From: Angela Haywood [REDACTED]
Sent: 24 May 2017 14:21
To: 'Stewart Pritchard'
Subject: RE: Barnham Windmill

Barnham Windmill - Proposed Mezzanine
Indicative Section

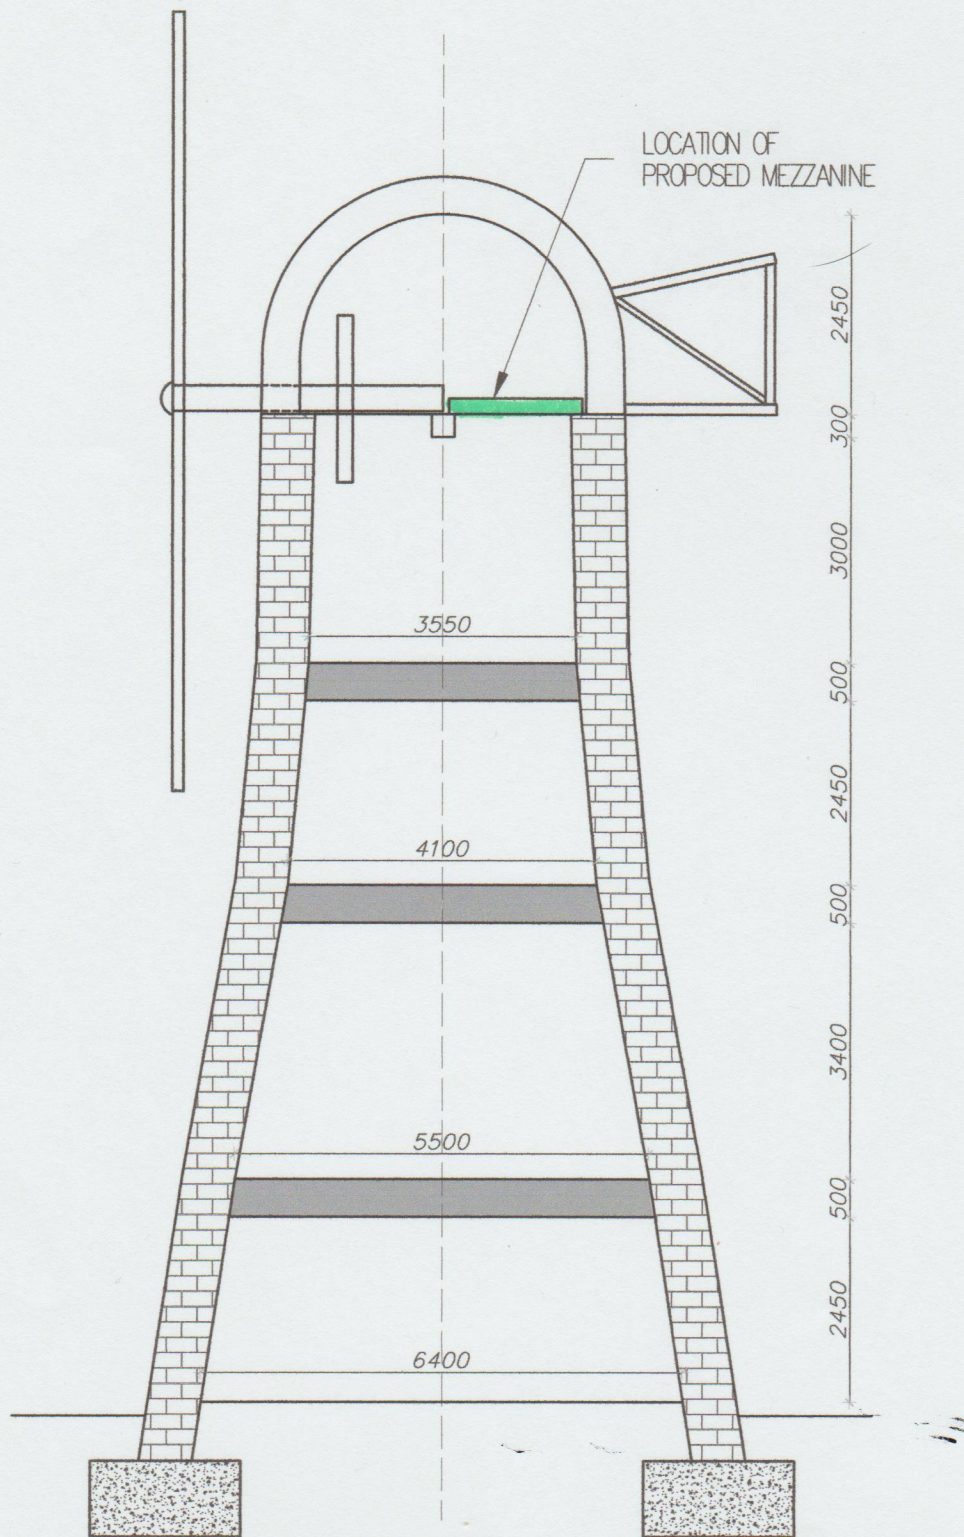
Further to our discussion today, I confirm that a full set of architectural drawings will not be necessary to support an application for listed building consent, due to the specific nature of the works involved. The detail drawings viewed during today's meeting, together with a vertical section drawing through the mill identifying the location of the new platform, will be sufficient to allow a clear understanding of the proposed works in this particular case.
